Bramford to Twinstead Reinforcement

Document 8.4.3 (B): Errata List

Final Issue B
November 2023

Planning Inspectorate Reference: EN020002

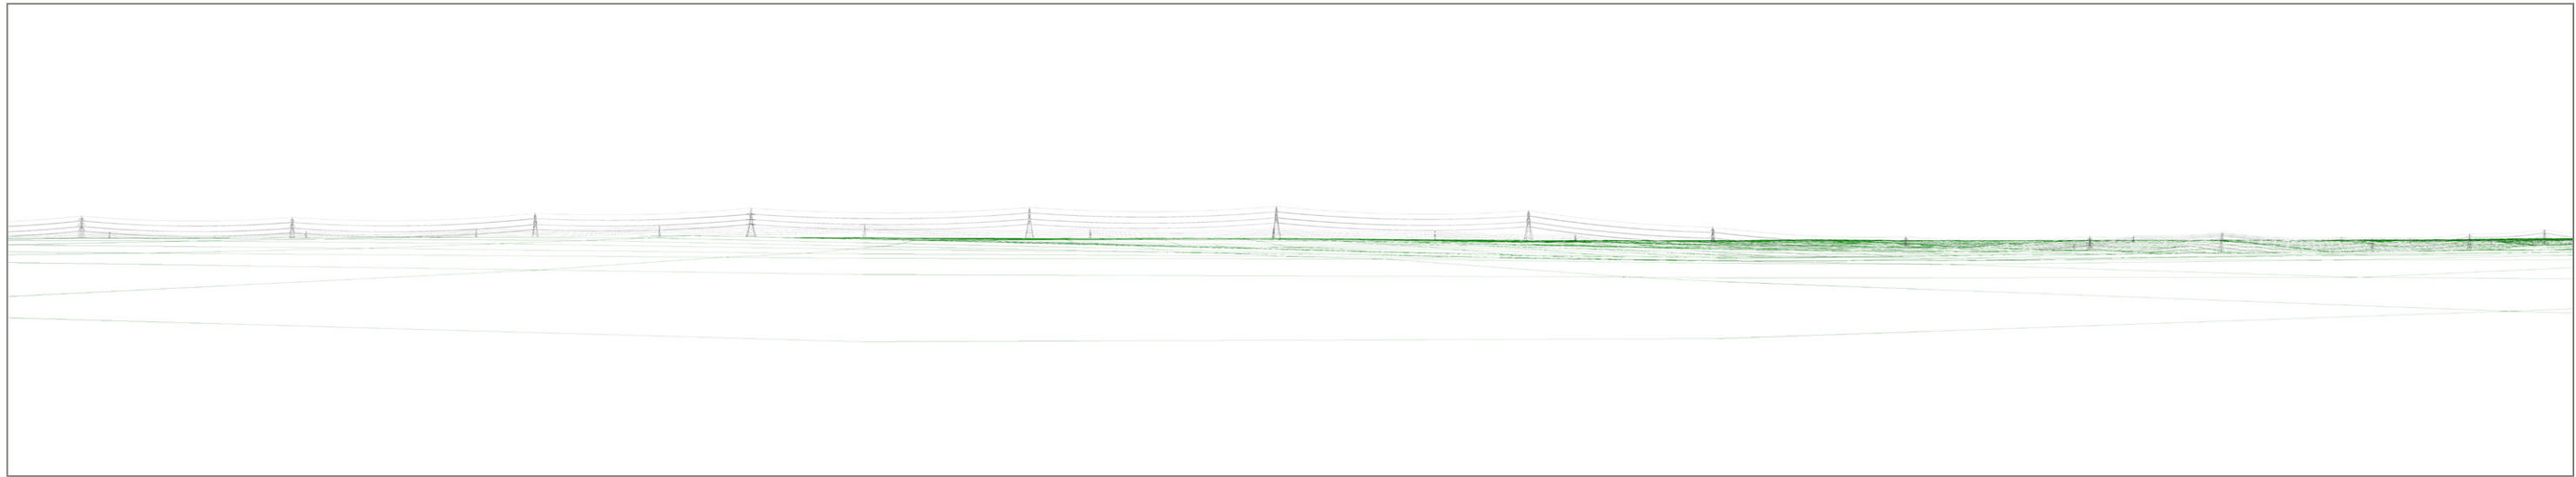
Deadline 4 Updates (16 November 2023)				
[APP-160]	Planning Statement	Section 4.3.3	Typographical	The following entry: is amended to read, ' <i>For the purposes of the local planning policy assessment, Section A (Bramford Substation) and Section B (Hintlesham) are addressed separately, although, these are combined into a single Section AB (Bramford/Hintlesham) elsewhere in the application. This recognises that Section A (Bramford Substation) falls within Mid Suffolk District, whereas Section B (Hintlesham) falls within Babergh District Mid-Suffolk District.</i> '
[APP-092]	ES Appendix 4.3, Greenhouse Gas Assessment	Paragraph 2.1.2	Typographical	The Carbon Asset Database underpinning the carbon calculations incorporates all appropriate GHG in the CO2e within the data. Paragraph 2.1.2 should have more accurately referenced 'CO2e' rather than 'CO2'.
[APP-101]	ES Appendix 6.4 Viewpoint Assessment Section AB Part 1	Wireline of viewpoint AB01	Error in the wireline of viewpoint AB01	The wireline was mistakenly orientated at 225°, whereas to align with the photograph it should be at 192° i.e. in a more southerly direction. This correction has been made

Document Number	Document Name	Paragraph / Section Reference	Nature of Erratum	Remedial Text, Reference or Narrative
				<u>to the wireline and revision B has been submitted at Deadline 4.</u>
[APP-105]	<u>ES Appendix 6.4 Viewpoint Assessment Section F Part 5</u>	<u>Wireline of viewpoint F01</u>	Error in the wireline of viewpoint F01	The pylon illustrated in the wireline showing the project was mistakenly illustrated as a suspension pylon. The pylon illustrated should have been a tension pylon. This correction has been made to the wireline and revision B has been submitted at Deadline 4.
[REP3-026]	<u>CEMP Appendix A – Code of Construction Practice</u>	<u>GH07</u>	The HRA Report was updated at Deadline 1 with the then current wording of GH07 [REP1-007/008] . However, the wording has been further updated following the Environment Agency's Written Representation [REP2-023] and this has been reflected in the CoCP which has been updated at Deadline 3 [REP3-026] .	The following entry: is amended to read, 'A <u>hydrogeological risk assessment will be undertaken once the trenchless crossing method has been confirmed. This will assess the risks on groundwater or surface water quality associated with the construction method including considering the potential for breakout during drilling and the use of bentonite or other agents proposed. Where the assessment identifies an unacceptable risk to groundwater or surface water quality, then alternative methods and/or additives shall be proposed, assessed and used. The hydrogeological risk assessment will be submitted to the Environment Agency for information prior to construction approval prior to construction. The Environment Agency will have up to 21 working days to respond on the hydrogeological risk assessment and their comments will be considered as part of finalising the risk assessment. This can be supported by a pre-submission draft to reduce the risk of any delays.</u> '
